WEST SUSSEX COUNTY COUNCIL CONSULTATION

TO:	Arun District Council FAO: Mr S Davis
FROM:	WSCC - Highways Authority
DATE:	1 June 2021
LOCATION:	To rear of 94 - 100 Hook Lane Bognor Regis PO22 8AT
SUBJECT:	BR/124/21/OUT Outline application with all matters reserved except for access for demolition of existing bungalow to form new access and residential development of 6 No. chalet houses. This application affects the setting of the Upper Bognor Road & Mead Lane Conservation area.
DATE OF SITE VISIT:	Site known to officer
RECOMMENDATION:	Advice / No Objection
S106 CONTRIBUTION TOTAL:

Preliminary 4

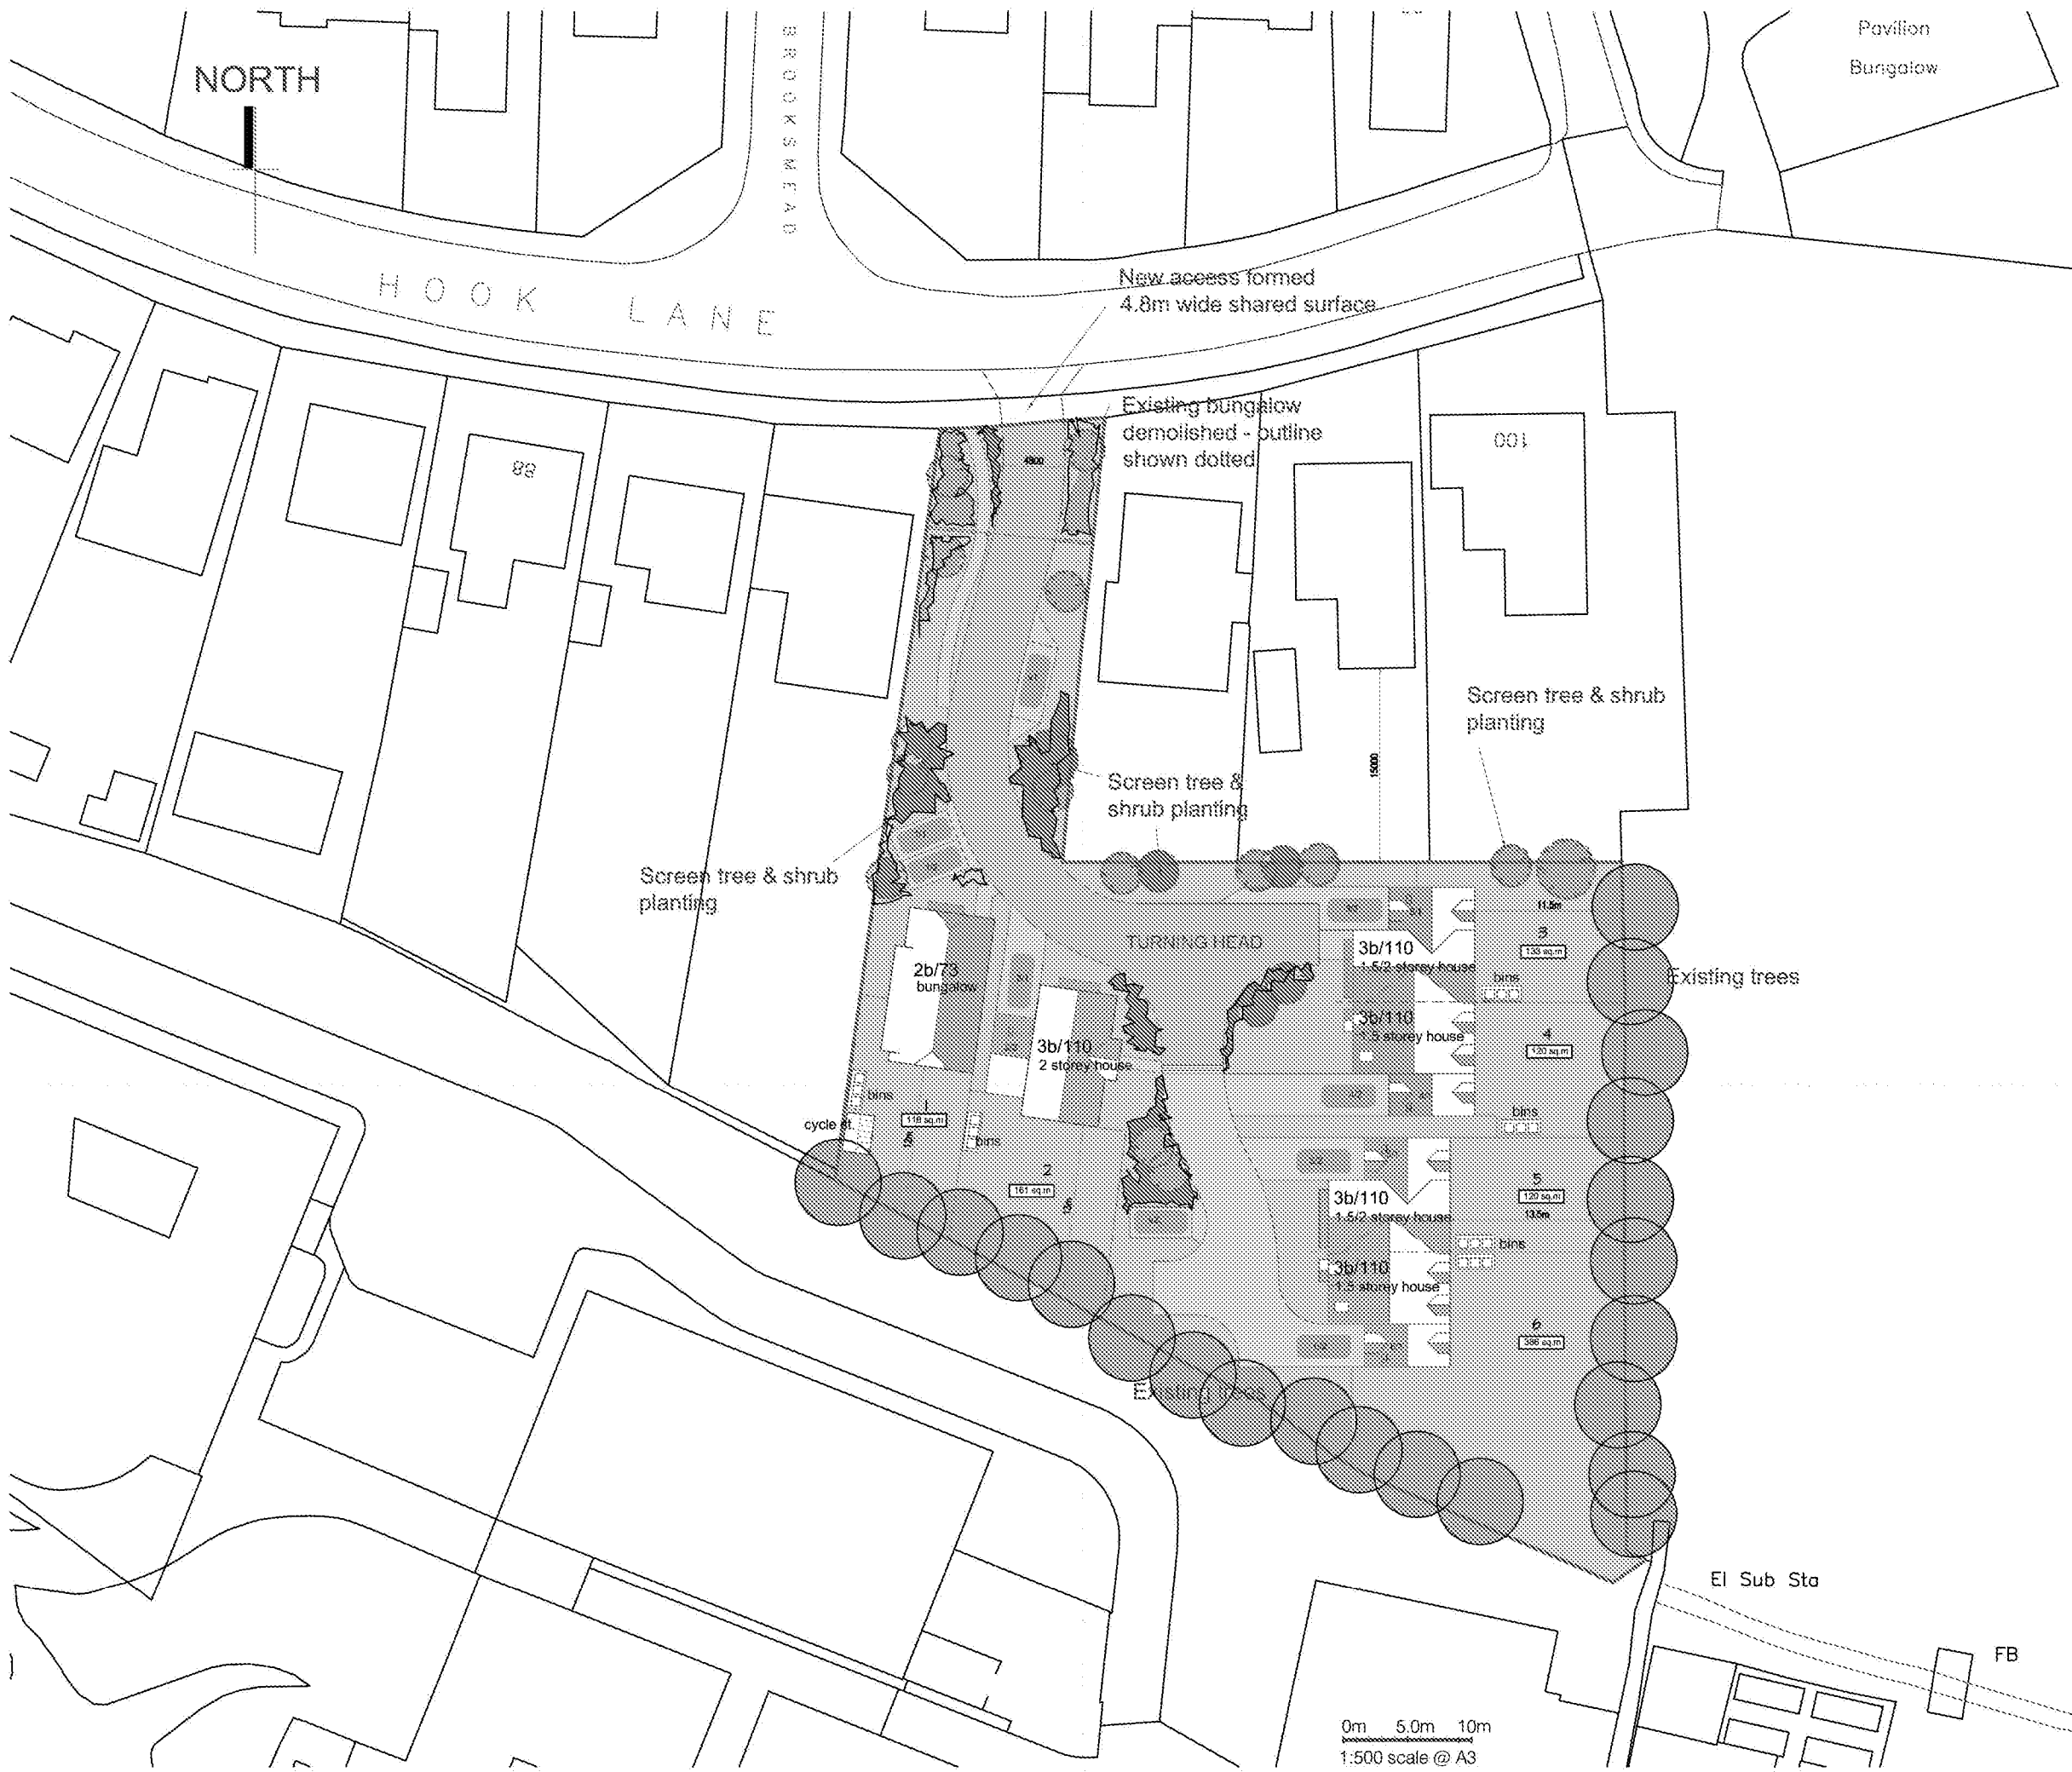
The access is shown on drawing no: 2.01 rev P4 as being 4.8m wide, this will allow two standard cars to pass. This is acceptable for this level of development. It is noted a turning head is shown on the site plan, the LHA would assume this means refuse collection will take place from within the site. If this is the case tracking will need to be provided at Reserved Matters stage to demonstrate that a refuse vehicle can enter, turn on site and exit the access safely in forward gear. It appears that there is currently one parking space outside the property which will be lost with the installation of the proposed access. There are double yellow lines on the opposite side of the road to stop parking occurring, so it's not expected that parking will restrict access movements to or from the site.
